Objection to Residential Development with affordable housing 11-19 Middle Harbour road Road Lindfield (SSD-82900461)

Project Name 11-19 Middle Harbour Rd
Project Number 13903
Project Address 11-19 Middle Harbour Rd
Lindfield NSW 2070

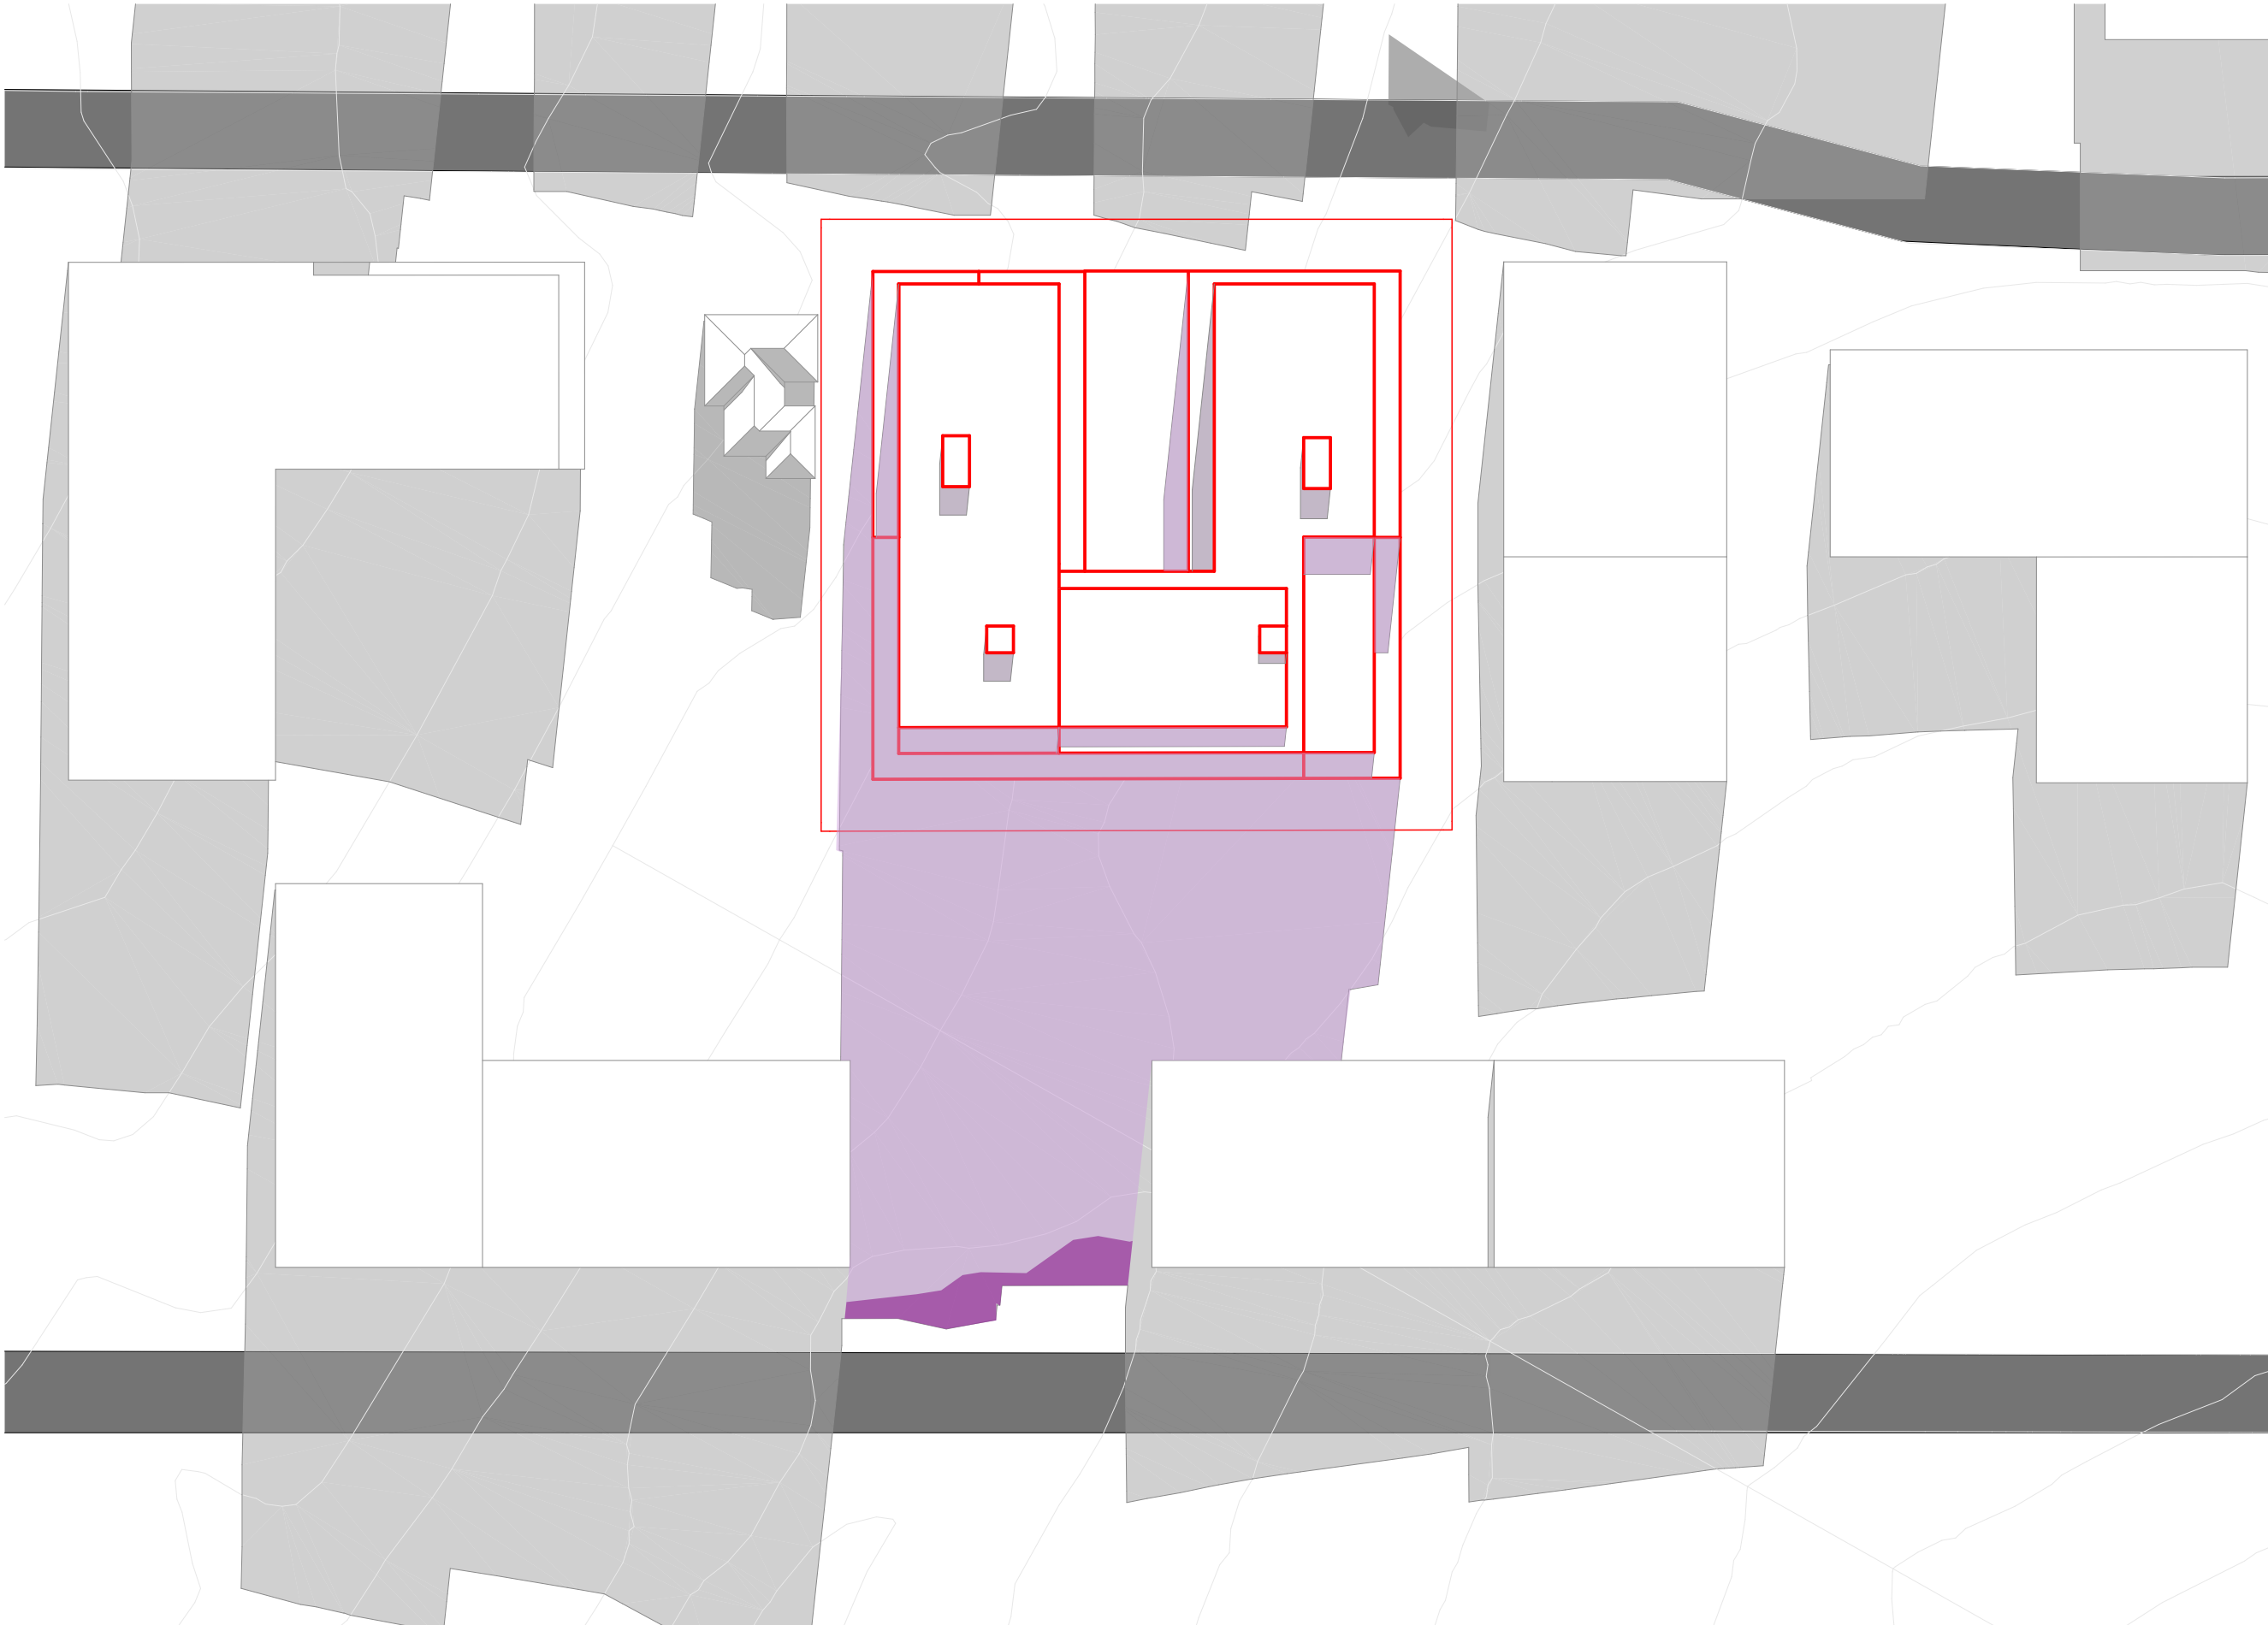
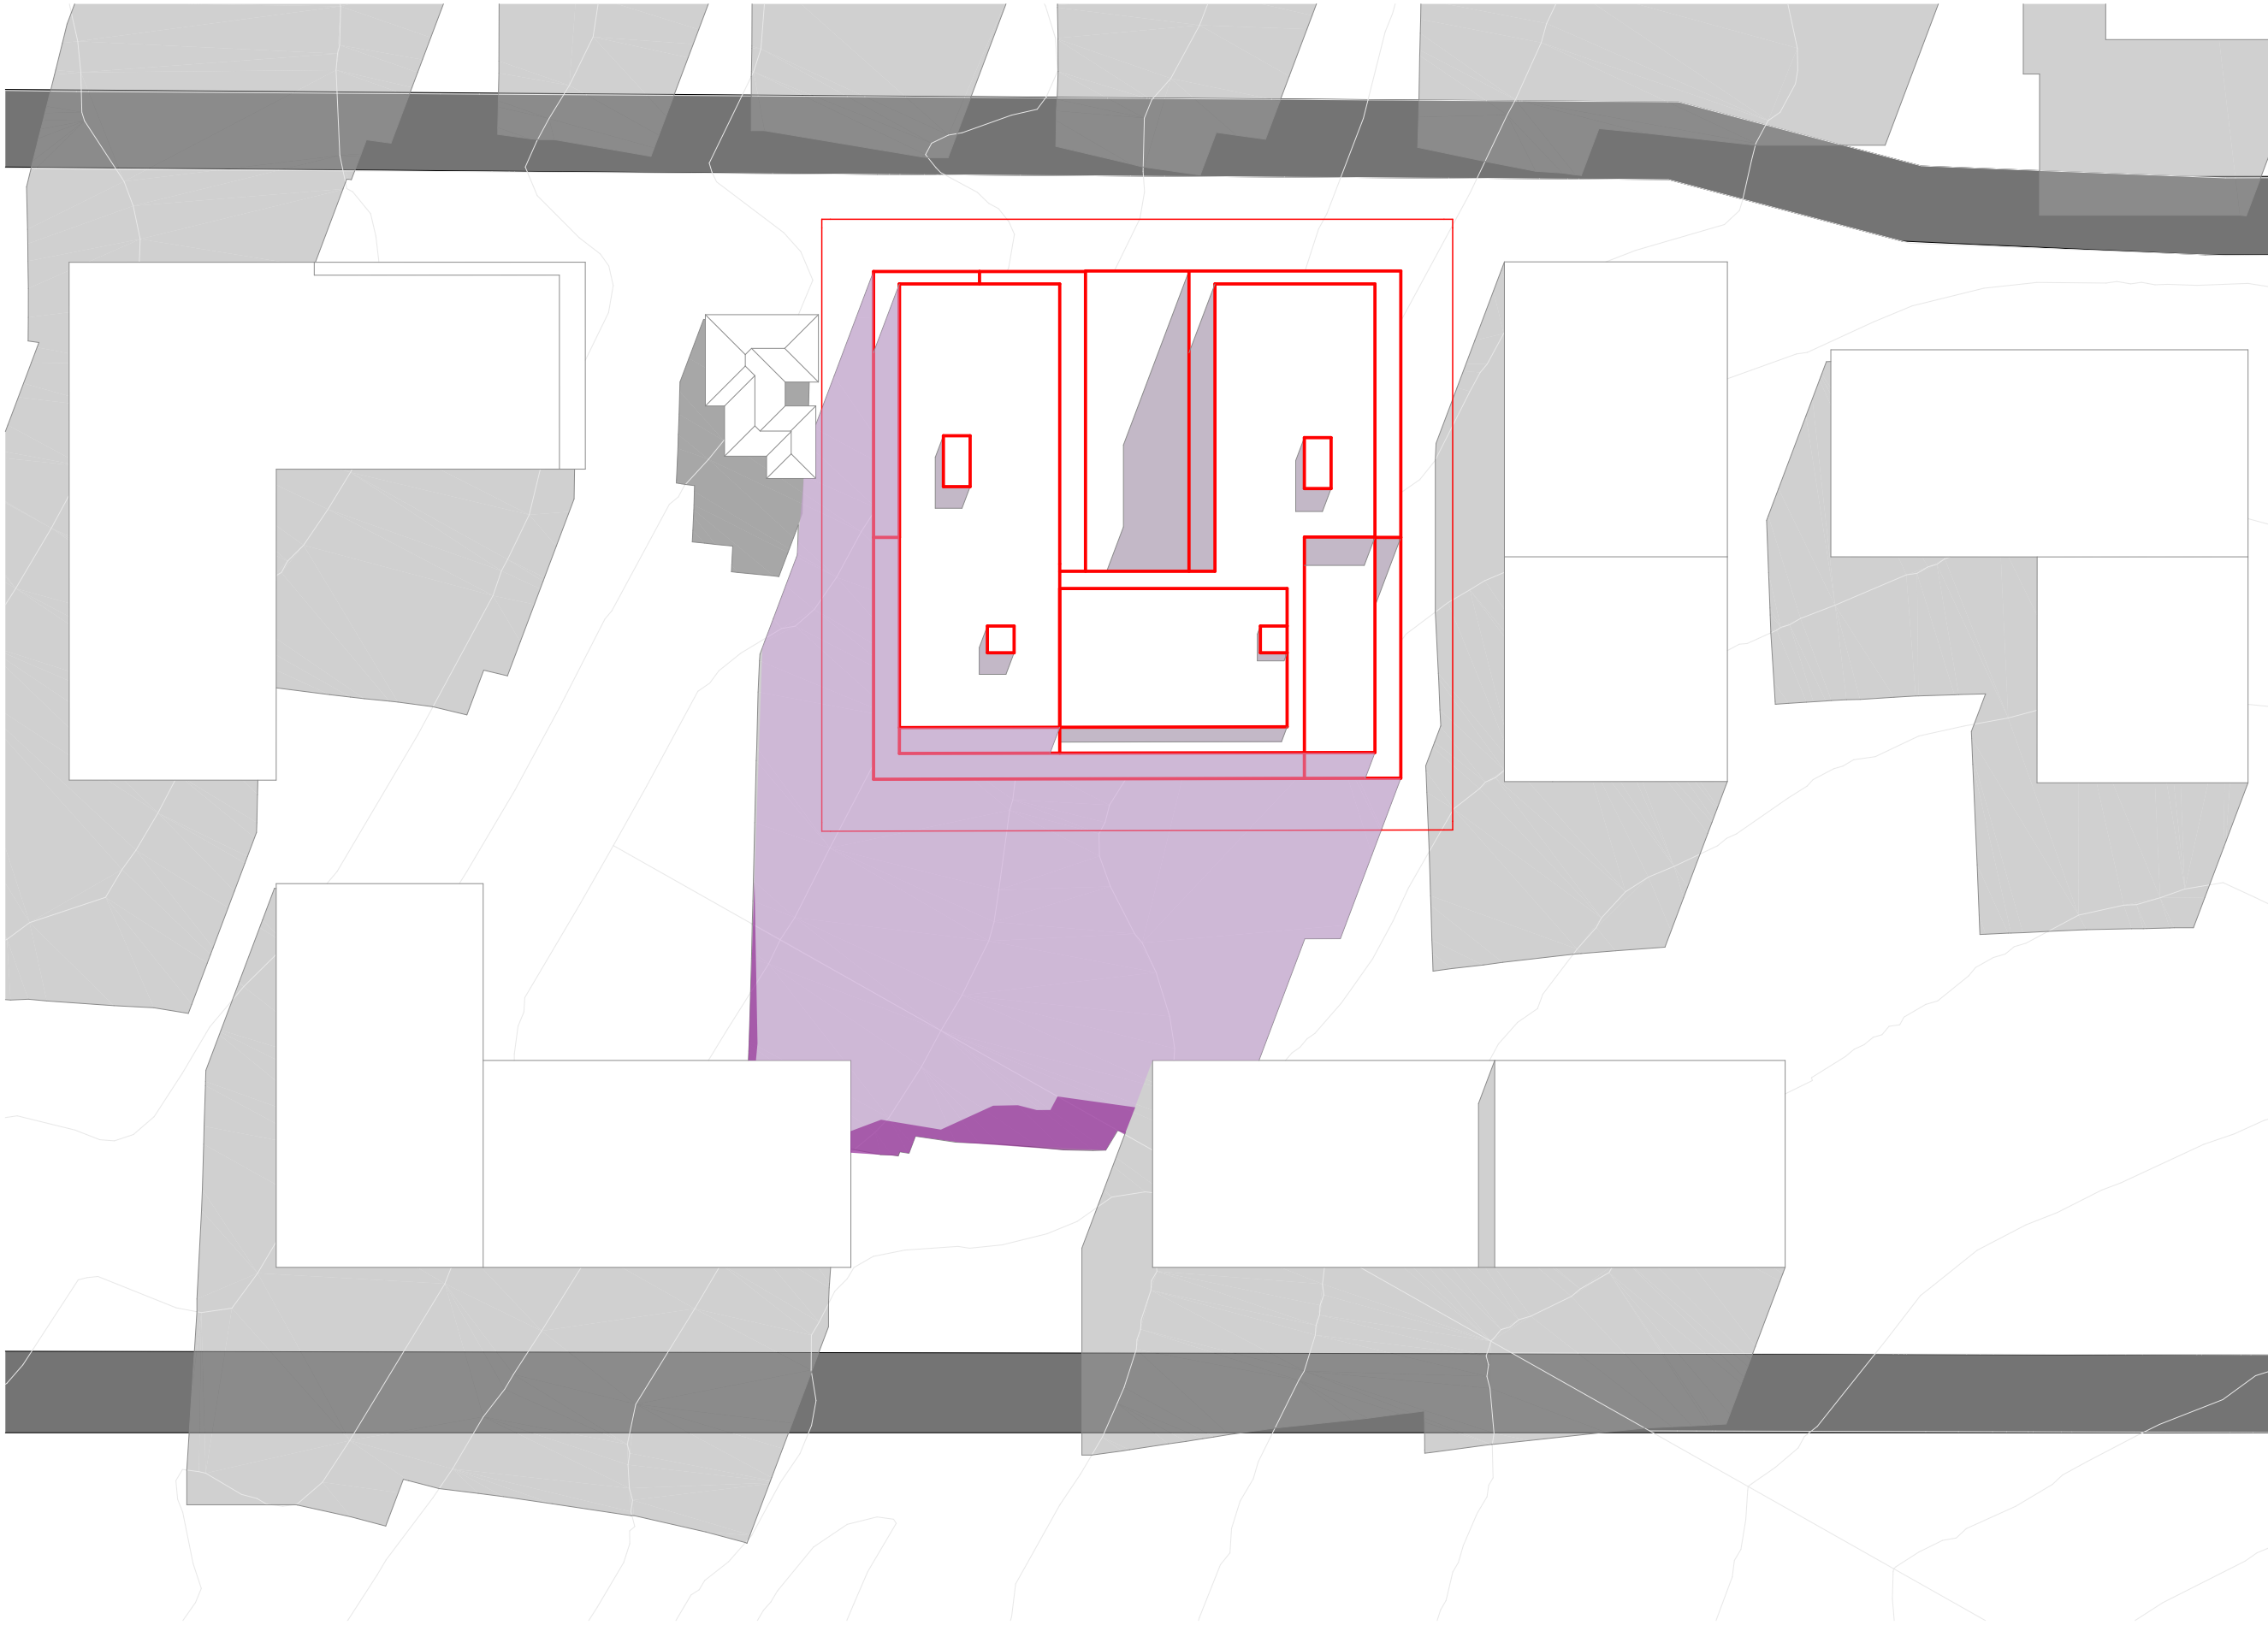
The land which "the Project" is located is higher in the north and lower in the south. Therefore, the setback on the southern boundary of "the Project" should be larger to minimize the shadowing effect on the buildings along Chelmsford Road, which are located at a lower elevation than the Project.

However, the Project does not actually follow the relevant setback rules of KCDP2024. Therefore, “the Project” will cause serious shadowing effect on the direct sunlight of the buildings along Chelmsford Road.

Deep Soil Calculation

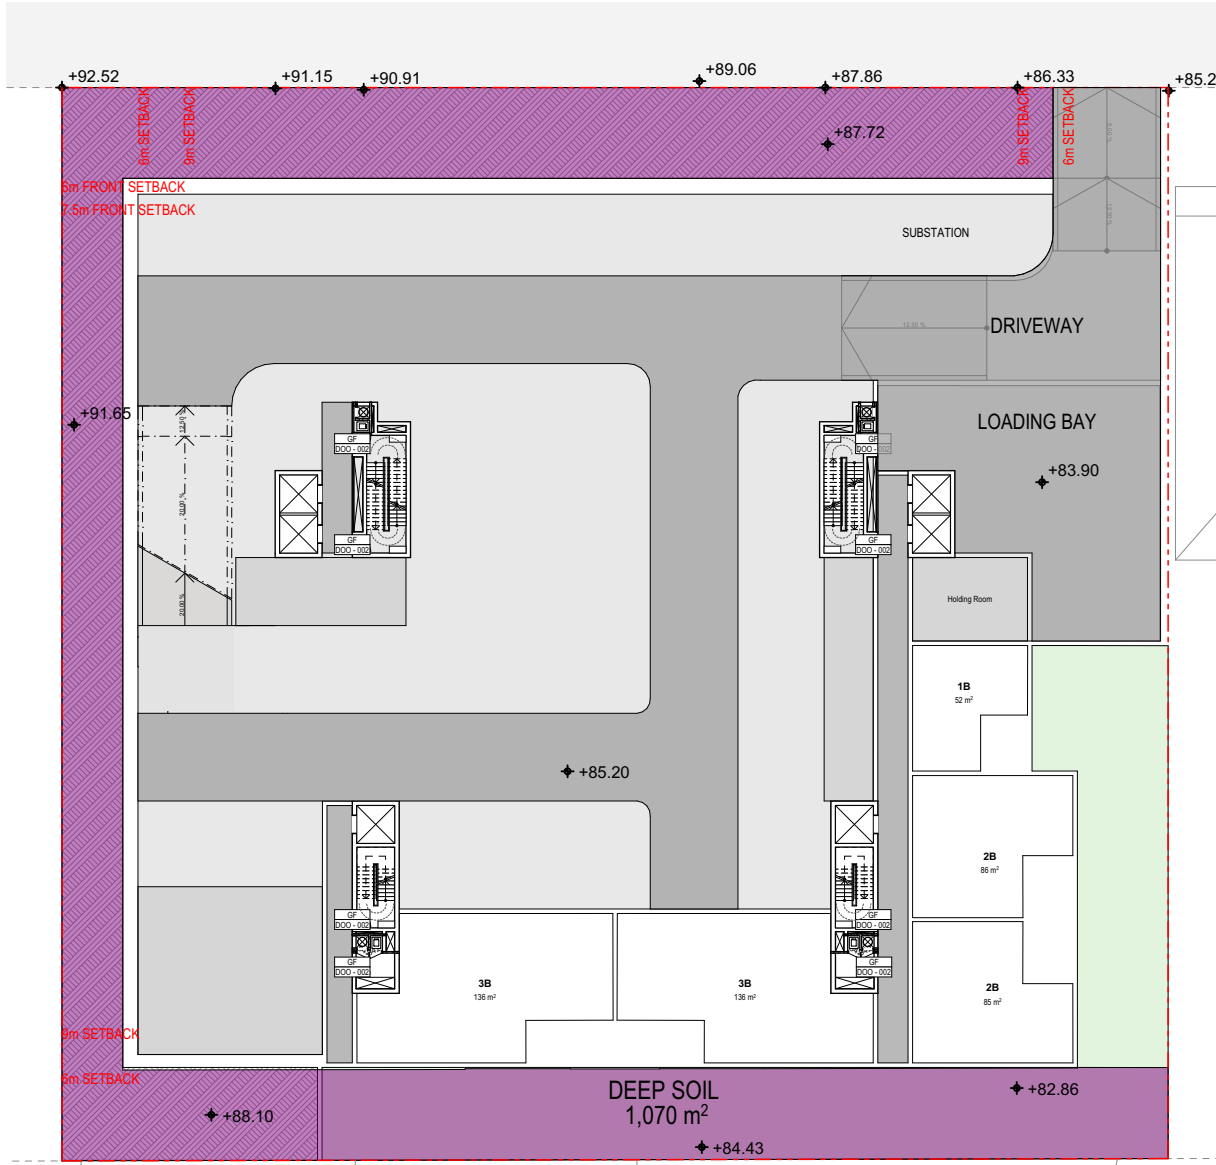
According to the proposal, the applicant will remove a significant number of mature trees. Furthermore, due to the project's underground parking exceeding the building footprint and the limited setbacks that already do not comply with current planning rules. The project's deep soil cover is very low, far below the KRG's minimum 50% requirement. This constitutes a serious violation of the deep soil zone principle and will prevent effective deep soil planting. This will further damage Middle Harbour Road's historic streetscape and beautiful green environment.
